Application No.: 21/03164/OBL

Proposal: Discharge of Golfing obligations of Schedule 2 of the Great Wolf Resort Section 106 Agreement of 19/02550/F

Location: Land Approx. 1 Mile from J9 East of M40, Part of M40 Through Chesterton Parish, Chesterton, Bicester

Submission of details pursuant to Clauses 3.1 and 4.1 to Schedule 2 of the S106 dated 24 March 2021

DETAILED DESIGN
ACADEMY GREENS

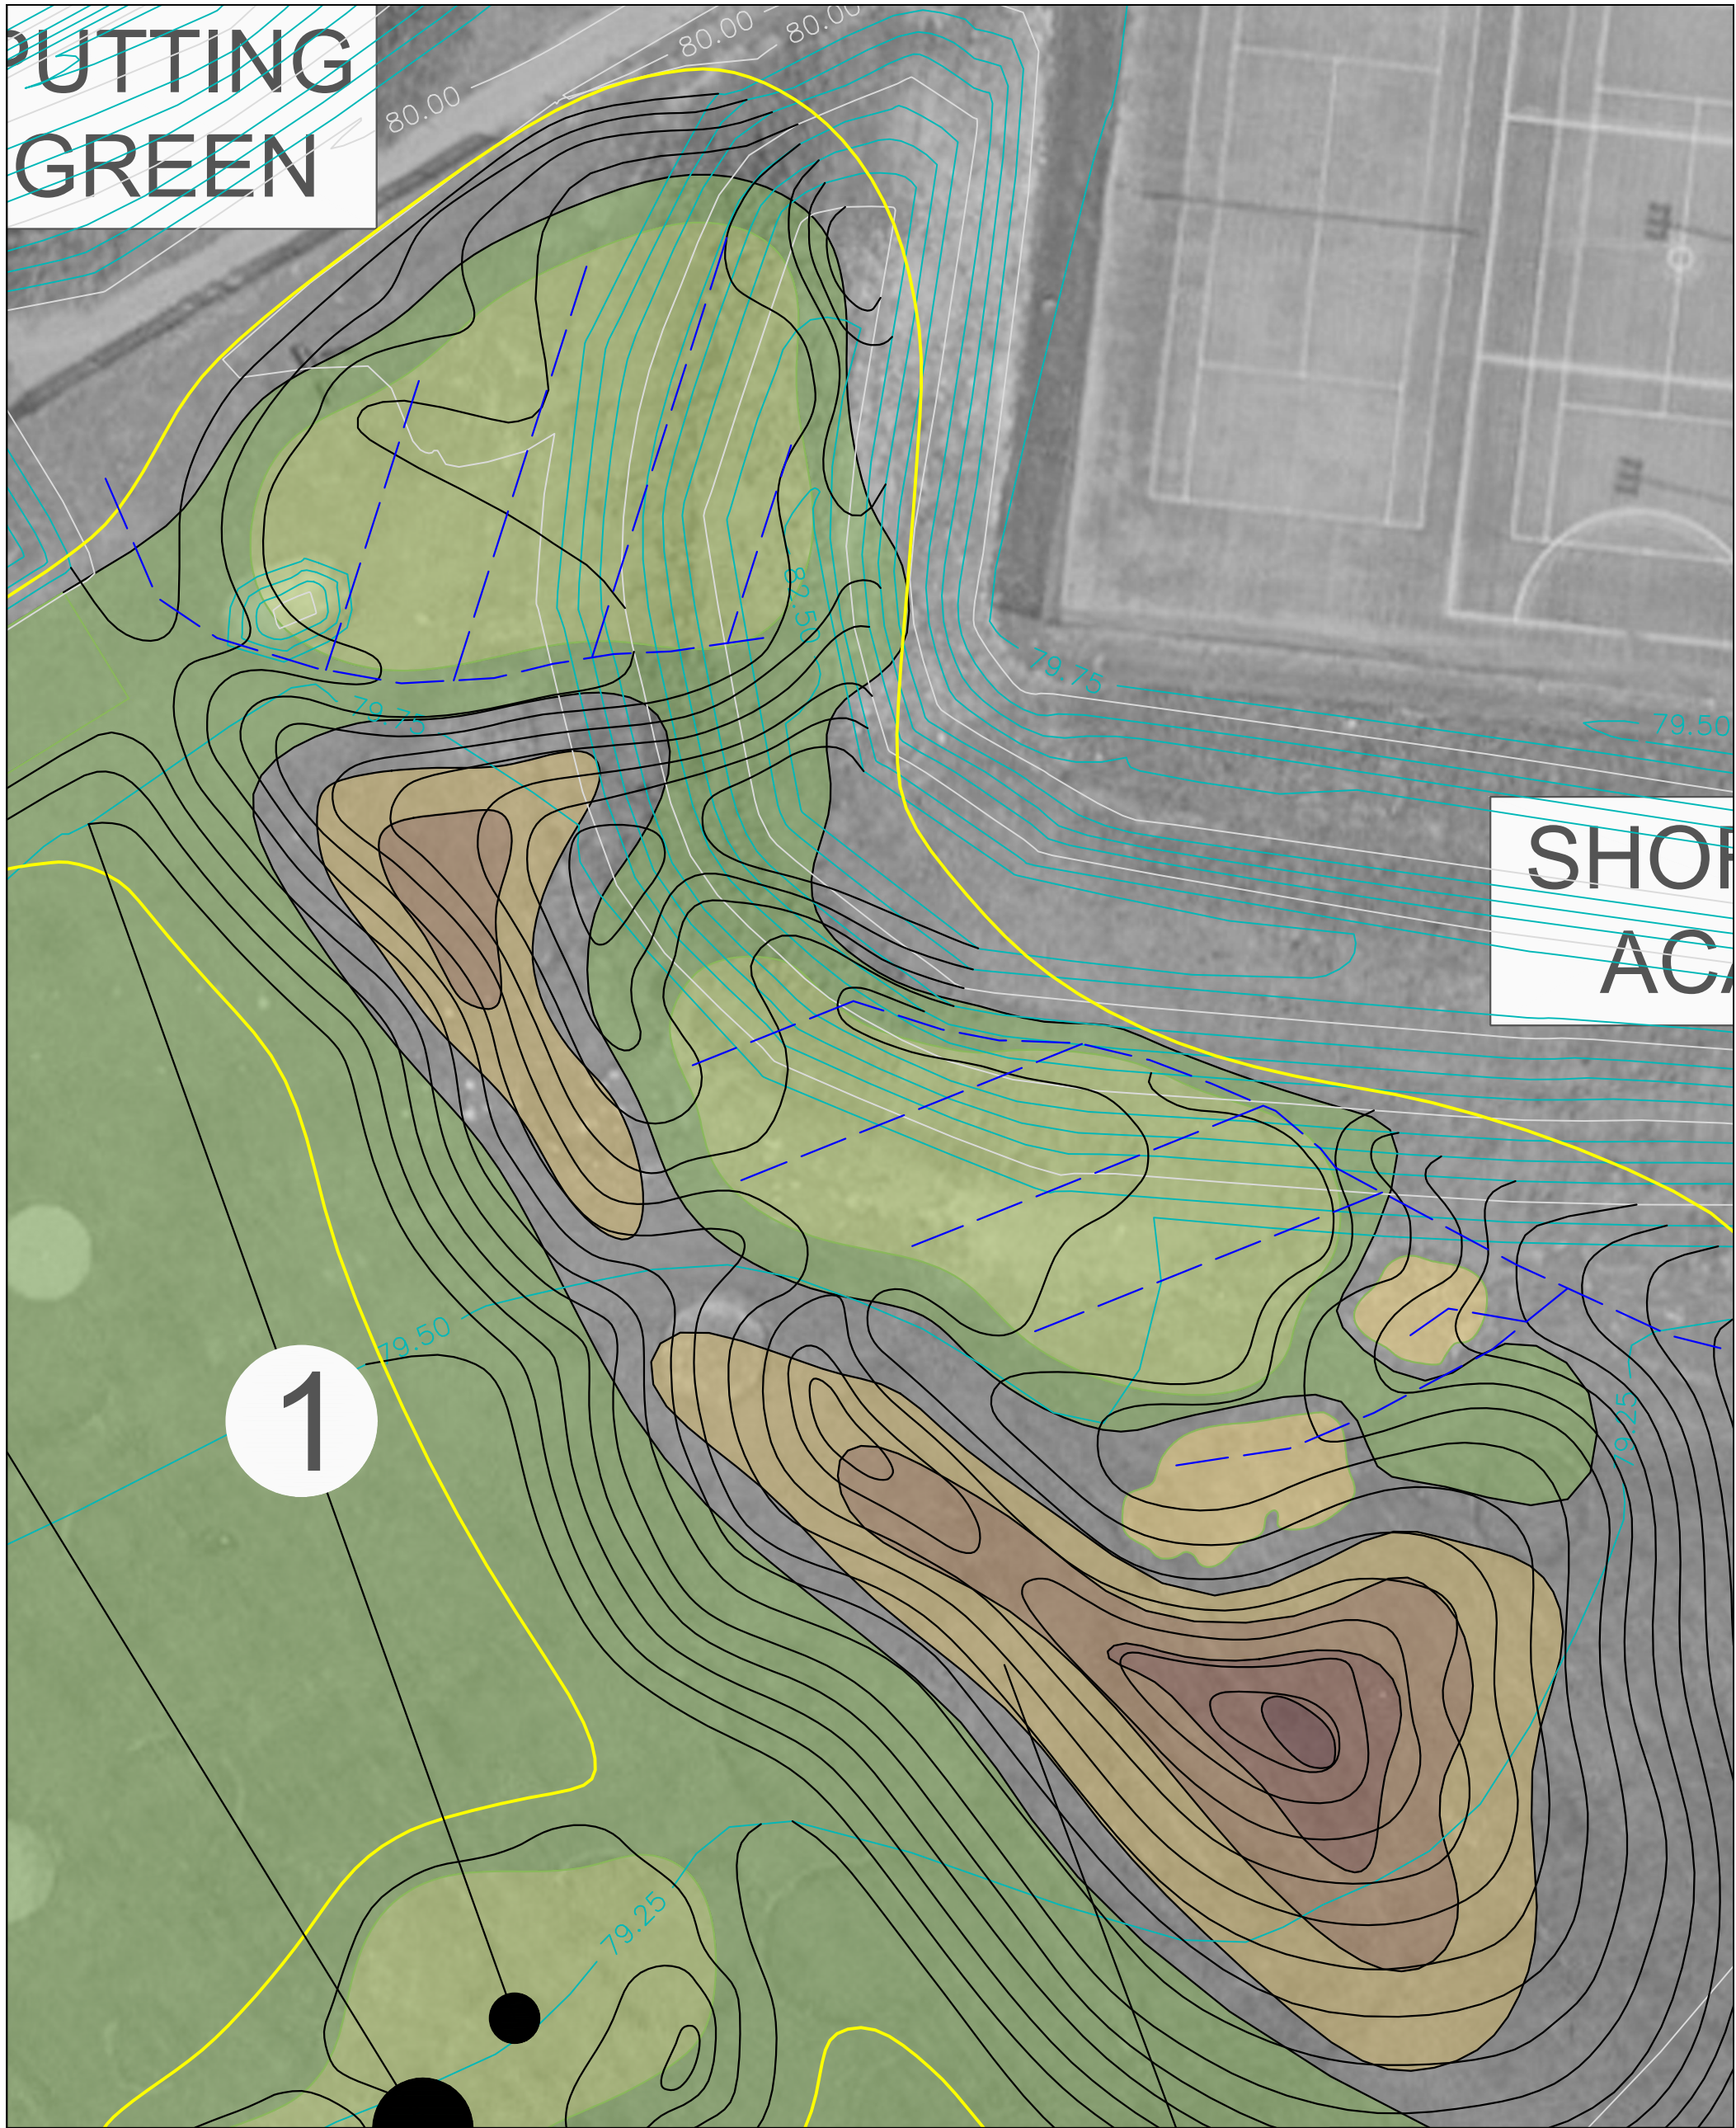
Given that the Driving Range Practice Facility comprising its 10 playing Bays and 3 teaching Bays will be no longer than a maximum of 225 yards and that the land to either side of the Range and proposed Par-3 Academy Course is in Third Party ownership and used for outdoor recreational swimming and agricultural purposes and all those surrounding areas would be within reasonable striking distance from stray golf balls, the proposed 10m-high, 25mm gauge mesh netting will need to extend all around the perimeter of the range, not simply confined to a total perimeter of 550m as originally proposed in order to ensure public safety.
